SUBJECT: WDFW COMMENTS ON VA-25-00001 Roe

Thank you for the opportunity to comment on VA-25-00001, a Zoning Variance Application to reduce the 10-foot side yard setback by 6 ½-feet on parcel 351834. The Washington Department of Fish and Wildlife (WDFW) is familiar with the area and has reviewed the application materials on file.

Critical Areas Map

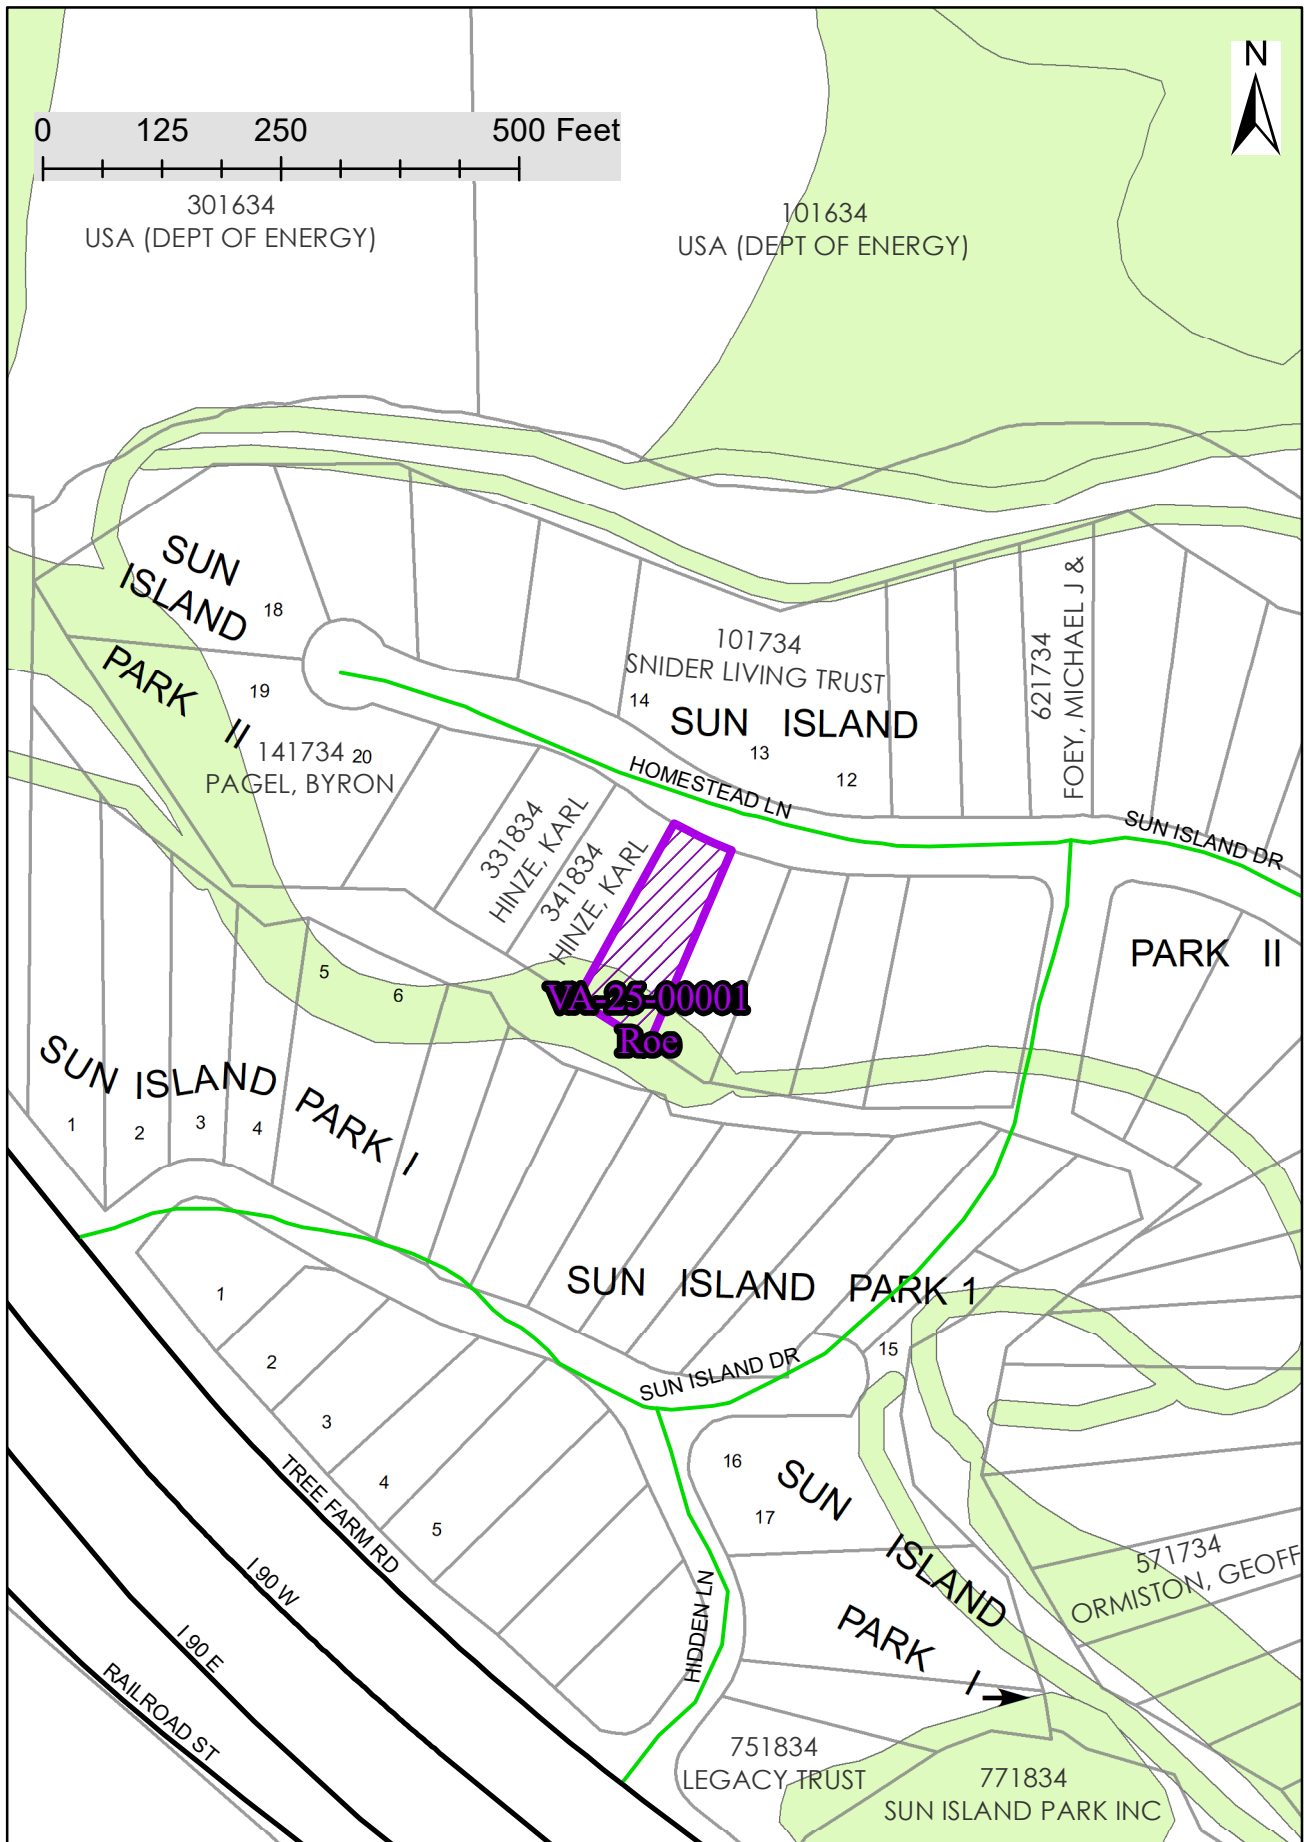
The property is wholly within the 100-year regulatory floodway and is mapped Shoreline Residential under Kittitas County's Shoreline Master Program. We understand this is an existing structure; however, the impacts to the floodway and Yakima River Riparian Management Zone (RMZ) should still be evaluated as they would with a new structure.

Kittitas County's Easton Reach Yakima River Flood Hazard Analysis and Mapping Investigation Report identifies on-going Yakima River streambank erosion in the vicinity of this parcel. To offset the impact of the structure within the Yakima River RMZ, we recommend planting riparian plants along the shoreline. The minimum planting area should be equal to the footprint of the structure to ensure no net loss of riparian function. Suggested plant species may include black cottonwood, mountain alder, coyote willow, red-osier dogwood, or similar native riparian trees and shrubs. We recommend a Habitat Management Plan be developed, prior to approval of the variance, that describes the planting, including species, quantity of plants, planting locations and monitoring to demonstrate plant survival. WDFW would welcome the opportunity to collaborate and/or review the plan.
